**Our Case Number:** ABP-316119-23

**Re:** DART+ South West Electrified Heavy Railway Order - Hazelhatch & Celbridge Station to Heuston Station, and Hesuton Station to Glasnevin  
County Dublin and County Kildare

re: 6.3.15 Ref 110 - Sharon Matthews

Figure 5-61 Route 860 Aston Quay to Park West Avenue

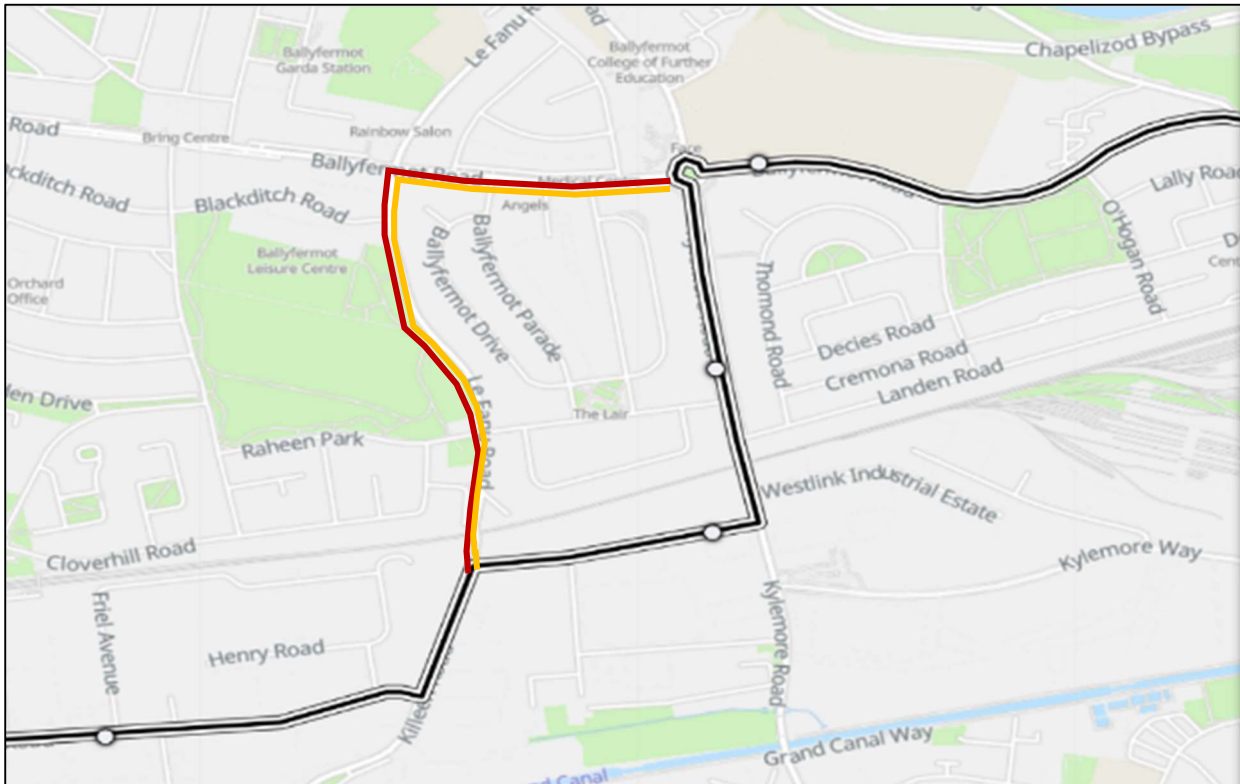
The response pushes the detail to a traffic management plan which locals will not have input into. Kylemore Avenue is not an appropriate road for traffic they will divert down it. It is right beside a playground, it has speed bumps and cars are parked on street, narrowing the streets. We already have issues turning from Kylemore Drive on to Kylemore Avenue due to traffic volumes during peak hours. Increasing the volume during the day will make it impossible to get out of the road.

We already have an issue with people using Kylemore Drive as a short cut because we do not have speed bumps and Kylemore Avenue do, that will increase with these diversions. Traffic should be diverted on to the main Kylemore Road and Le Fanu road and now down Kylemore Avenue.
